Application by Able Humber Ports Ltd for Able Marine Energy Park Material Change 2
The Examining Body's written questions and requests for information (ExQ3)
Issued on 15 February 2022

Responses are due by Deadline 5: 1 March 2022

Heights (Qu.1.0.3)

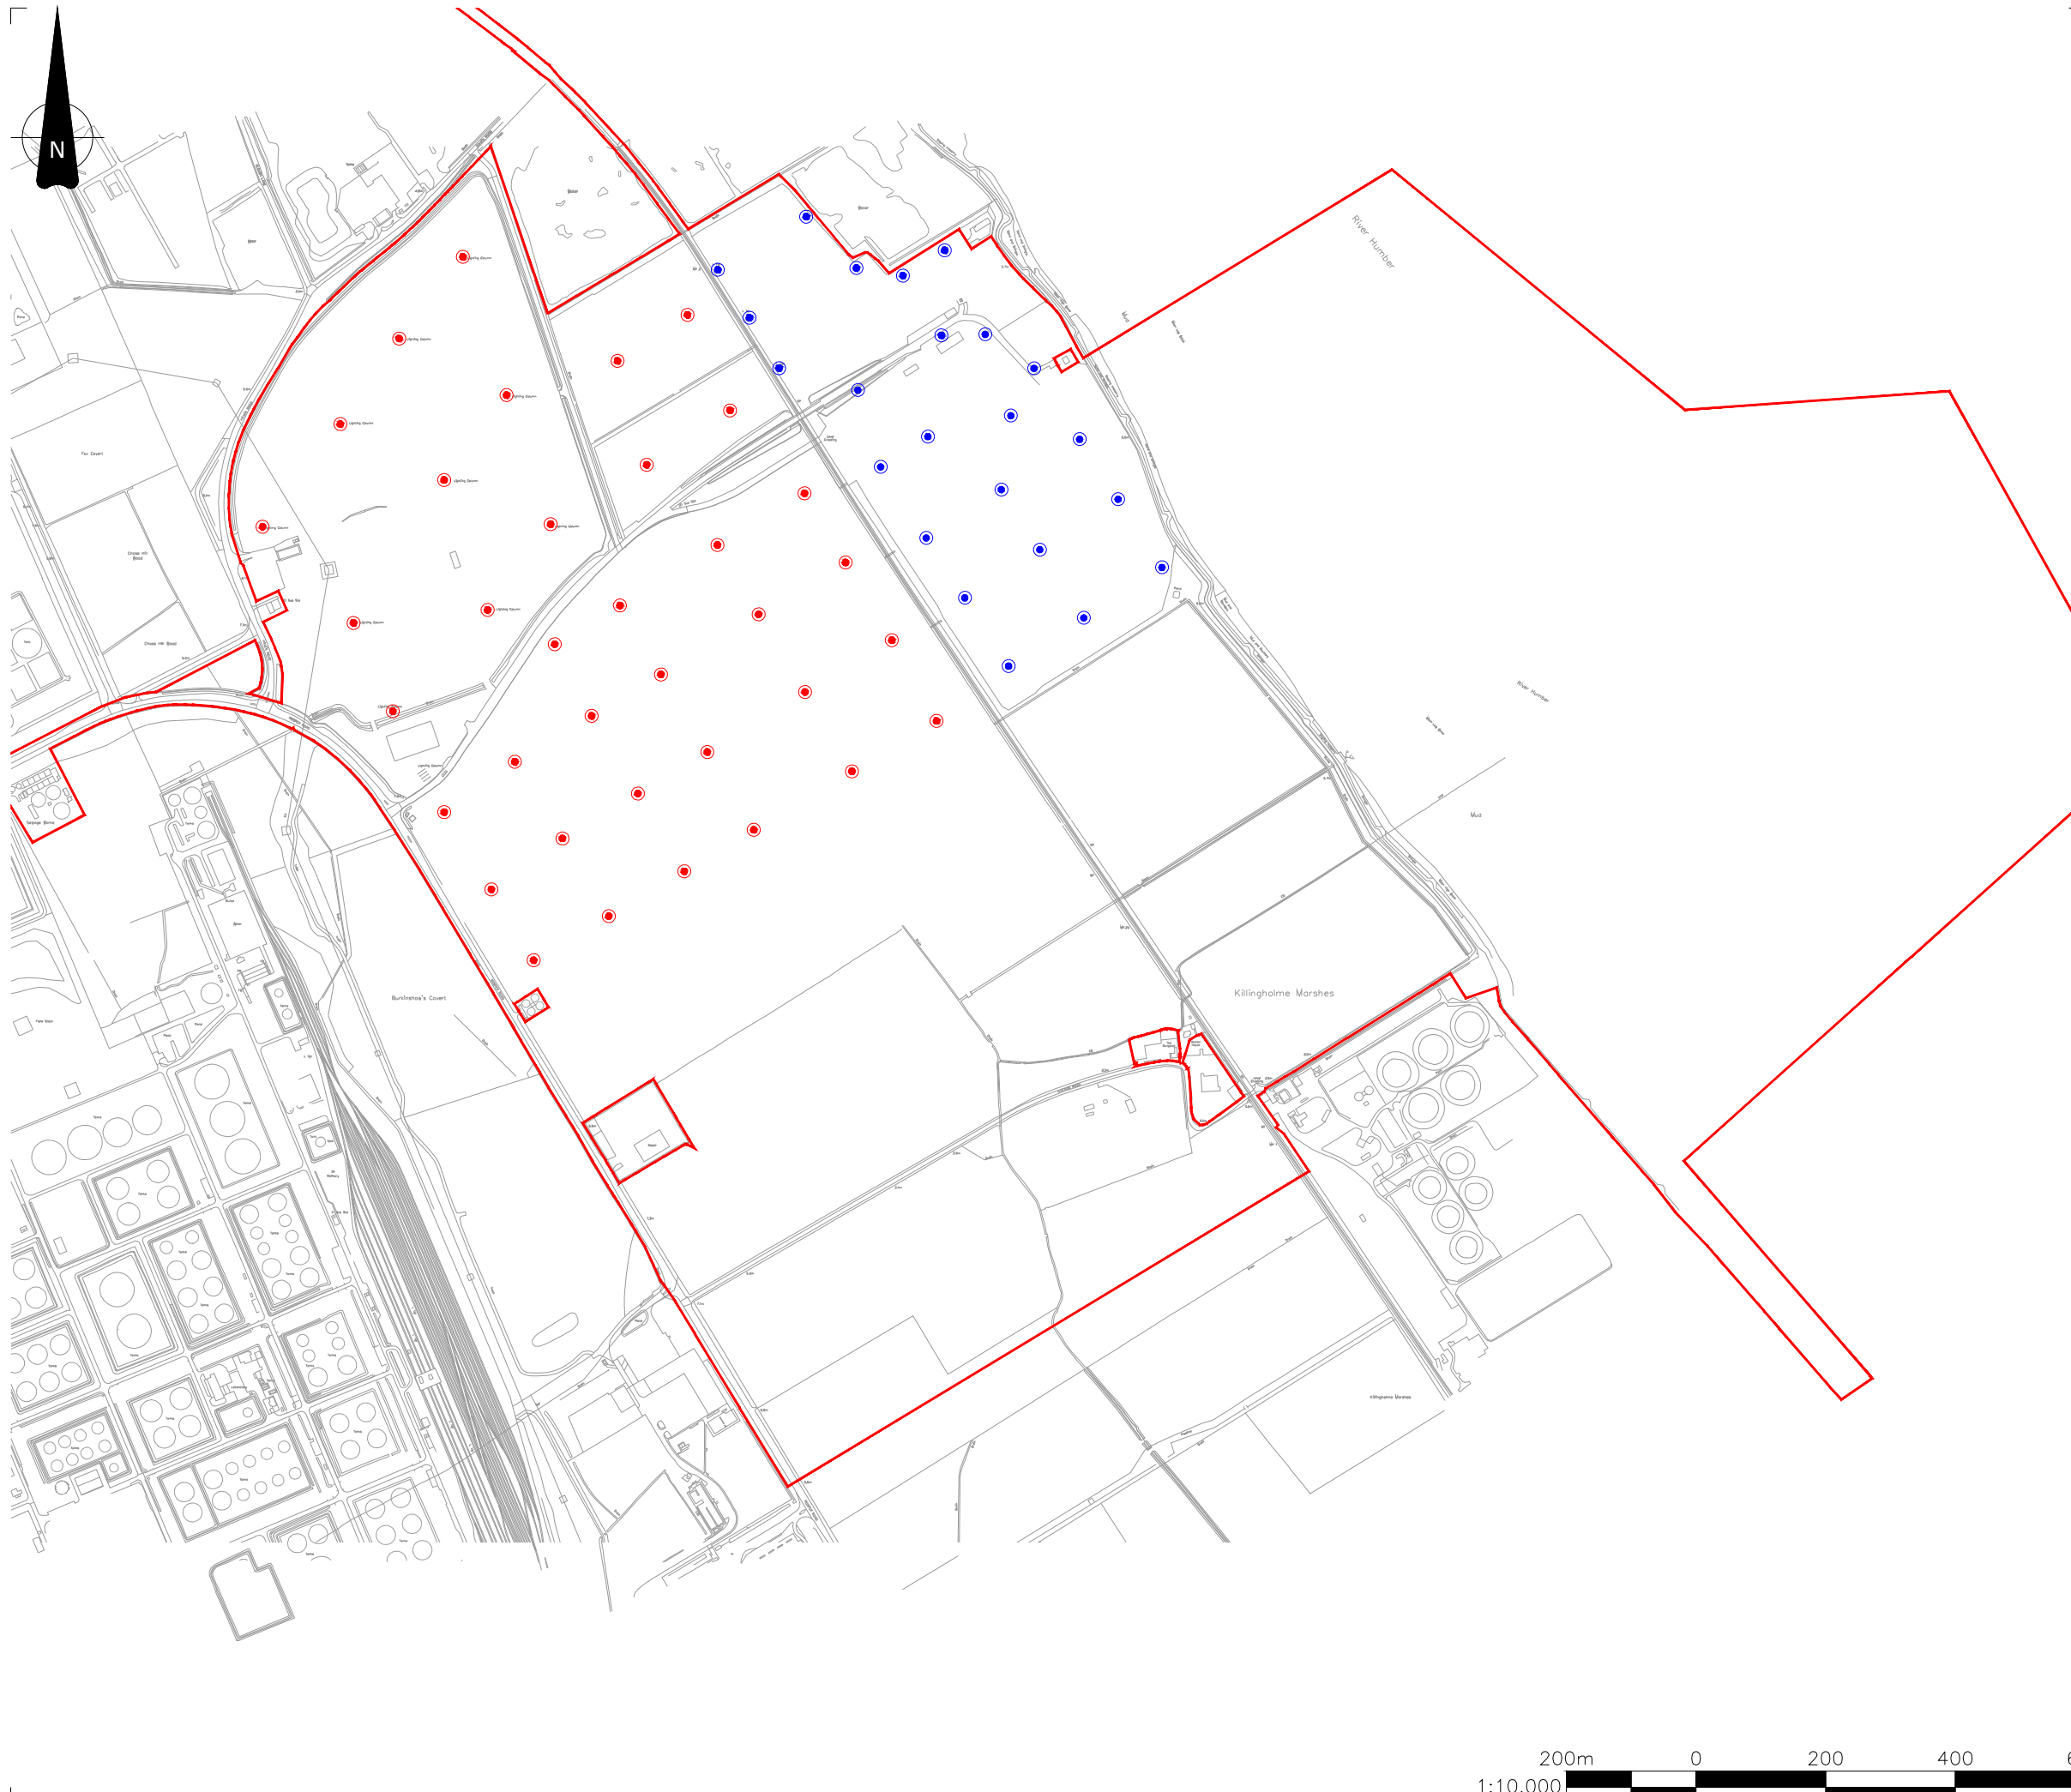
ExQ3	Question to:	Question:	
1. General and Cross-topic Questions			
Q1.01	All	Where up-dated documents are supplied, please supply a tracked as well as a clean version.	
Q1.02	App	Following the ASI of 10 February 2022, please supply copies of the drone photographs/videos relating to location P1.	
Q1.03	App	What height above ground level are the existing lamp standards on the northern part of the AMEP site?	
Q1.04	ABP	What height above ground level are the ABP silos to the south of the AMEP site?	
Q1.05	APP	Which of the Requirements of the DCO have been discharged? Would MC2 give rise to the need to revisit discharged Requirements?	
Q1.06	MMO	Is the MMO content with the Applicant's response in REP4-009 to its DL3 submission [REP3-019]?	
Q1.07	APP, MMO	Please report on the outcome of the meeting with the MMO to discuss changes to the DML.	
Q1.08	MMO	Re: ExQ2: 5.0.7 and 4.0.1, is the MMO content with the process of ascertaining the suitability of supplementary/amended monitoring within the MEMMP?
